**Consultation Response from Mike Hibbert,
 KC Waste Strategy(Refuse & Recycling)**

2022/93938 Piazza Shopping Centre, New Street and Albion Street, Huddersfield, HD1 2TR

Change of use from A1 (business retail and storage) to C3 (residential) 34 studio flats at first and second floors and external alterations

Responding Ref: WPS 22-77

**Important Notes**

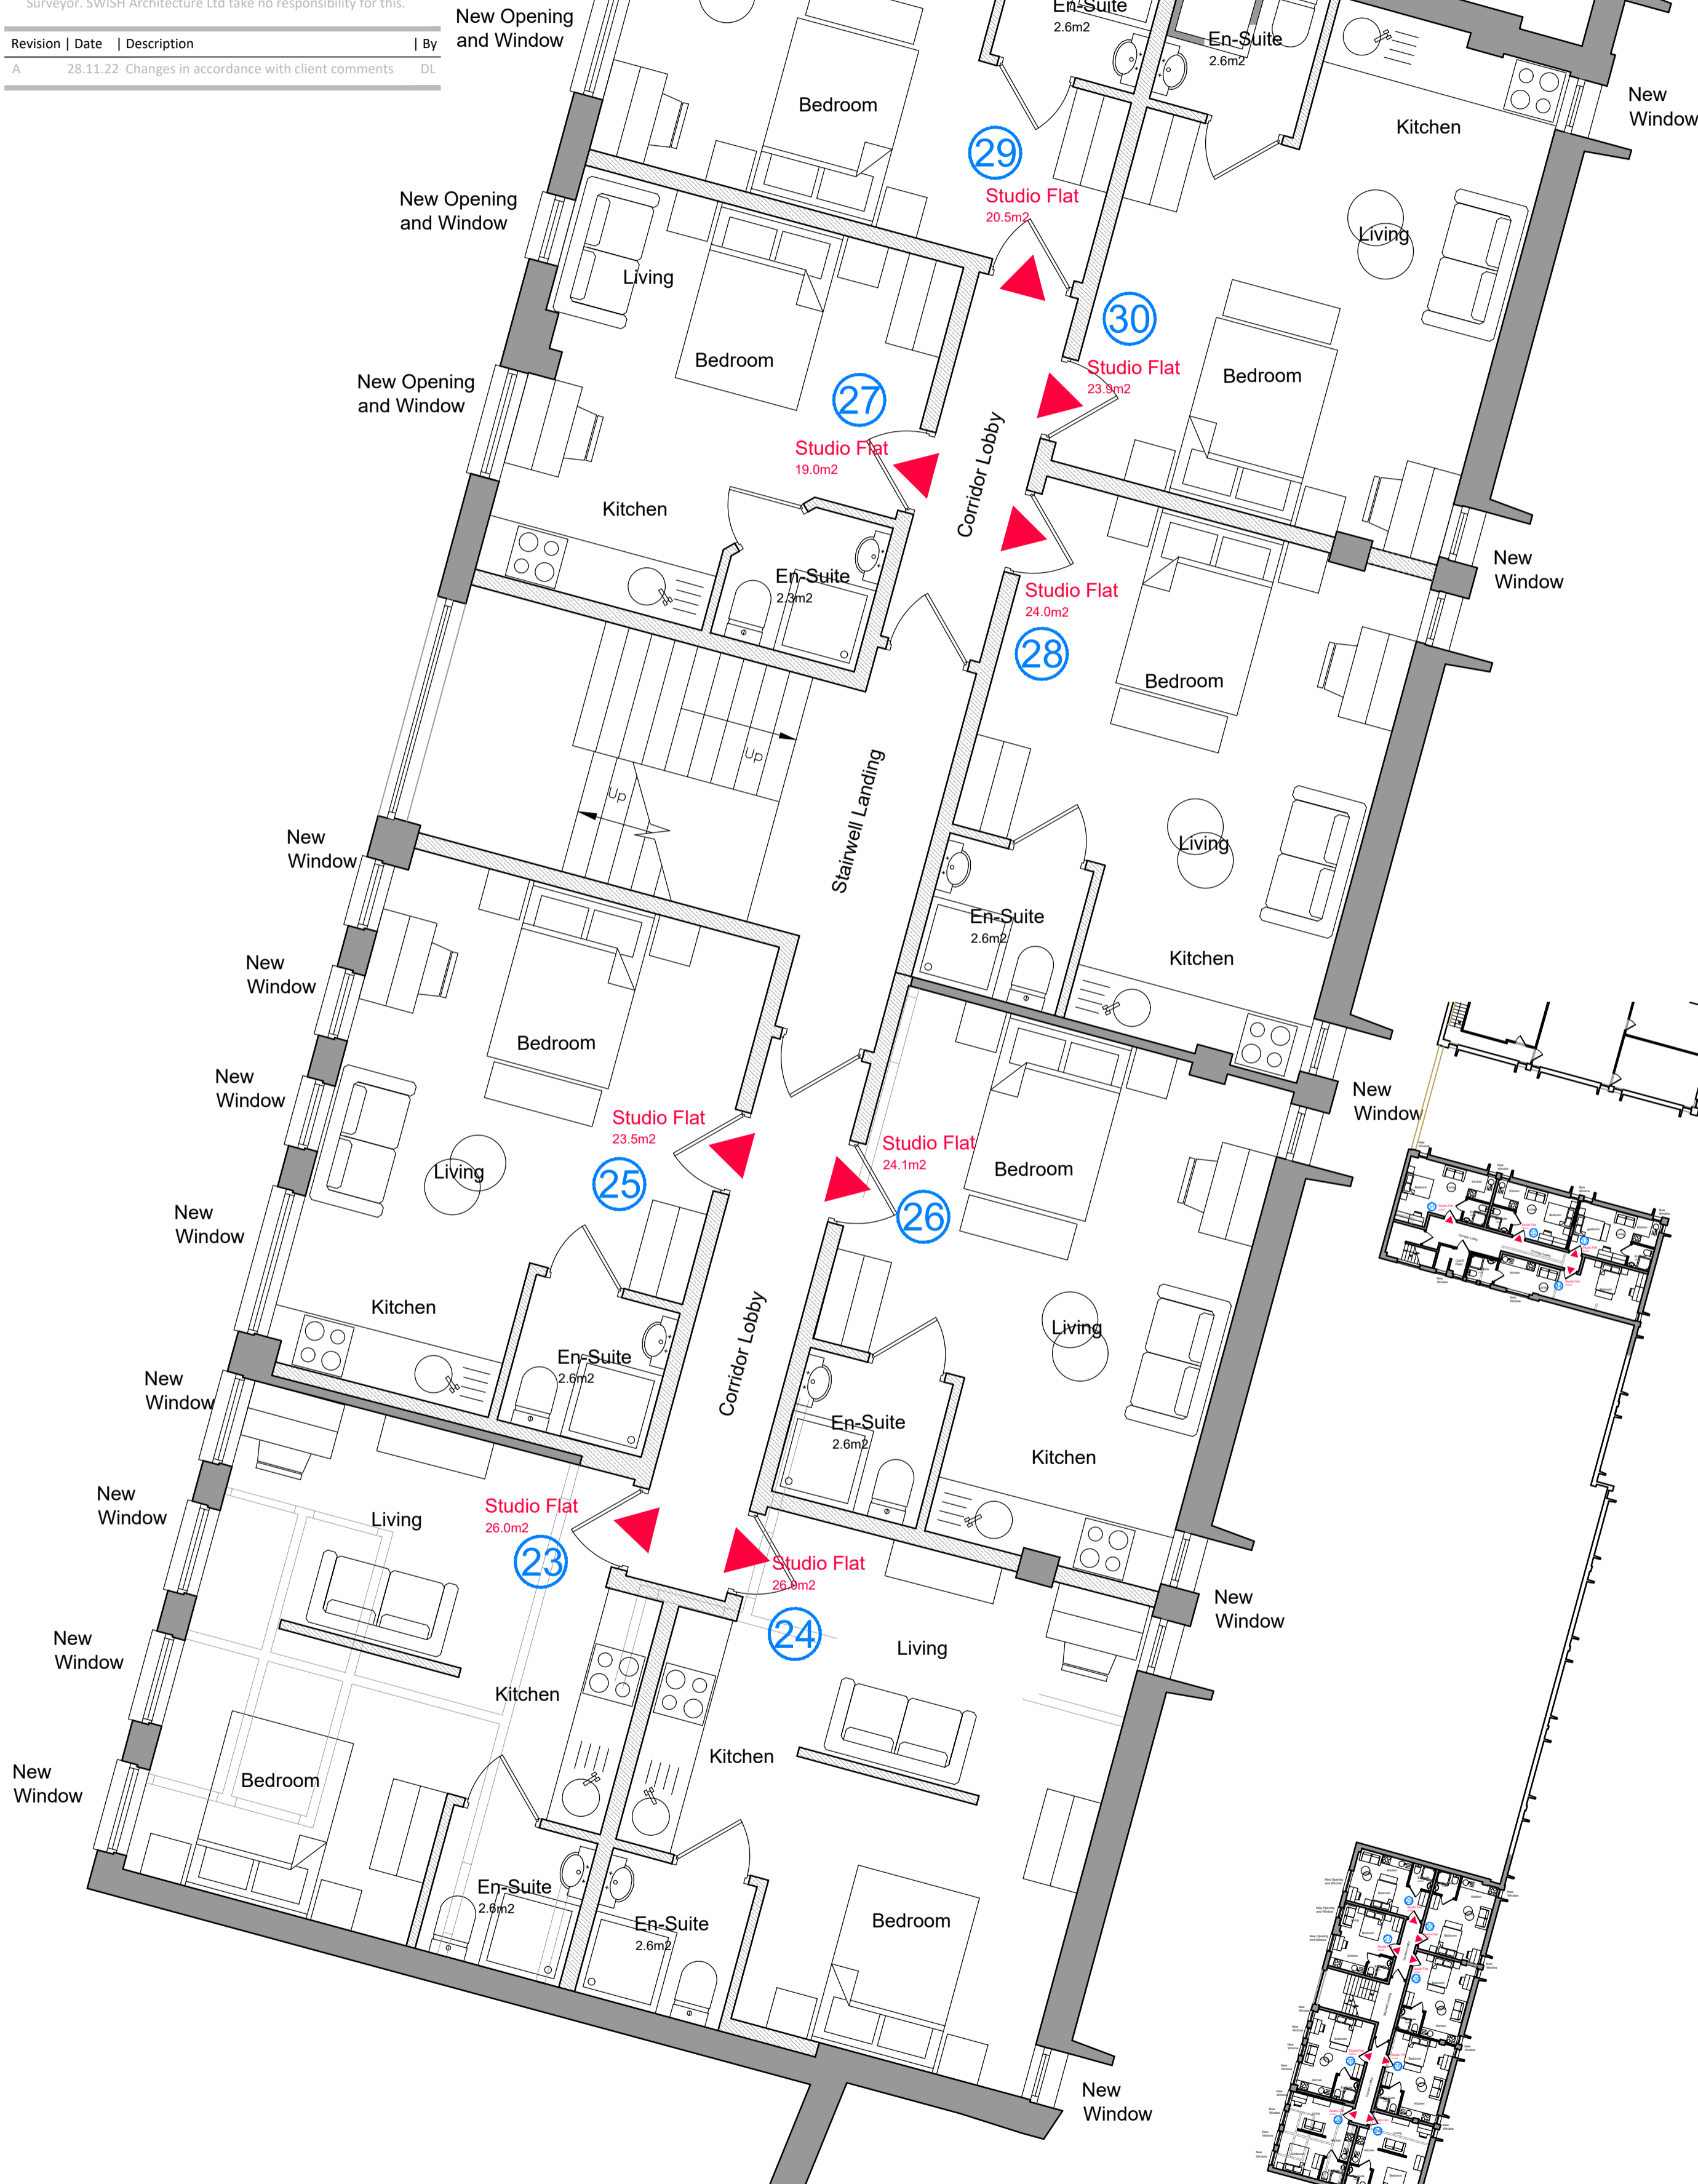
- Storage of wheeliebins on the pavement or roadway in New Street or Albion Street would not be acceptable.
- The applicant has not included any details on waste storage in the application form. The Design and Access statement dated 2/12/2022 states in Section 4.11 “Ample refuse storage is also provided for the proposal, with space allocated close to the proposed development to the internal courtyard of the site, as shown on the proposed site layout plan. Collections will be managed by a private collection company” and in Section 6.4 “Adequate refuse storage has been provided within the development to meet the needs of future residents for the lifetime of the development.” Despite reference to site plans proposed floor plan ref 22-60 .03 Rev A dated 7/12/2022 is not annotated to show details of a bin storage area.

- Guidance indicates the floor space for a 1100ltr wheeliebins is 1575mmx1190mm with space to manoeuvre the bins within the store so the bin store dimensions would depend on configuration within the store. There is no details of the exact location or design of the bin store provided. Additional information is required detailing waste storage, containers, capacity and design of the waste storage compound including,

- RCV Cleansing staff will not pull out the bins from the internal bin stores. There are no details of presentation points indicated on the plan of the site layout. Further information is requested on the location of presentation points and the arrangements in place to get the bins to presentation points.
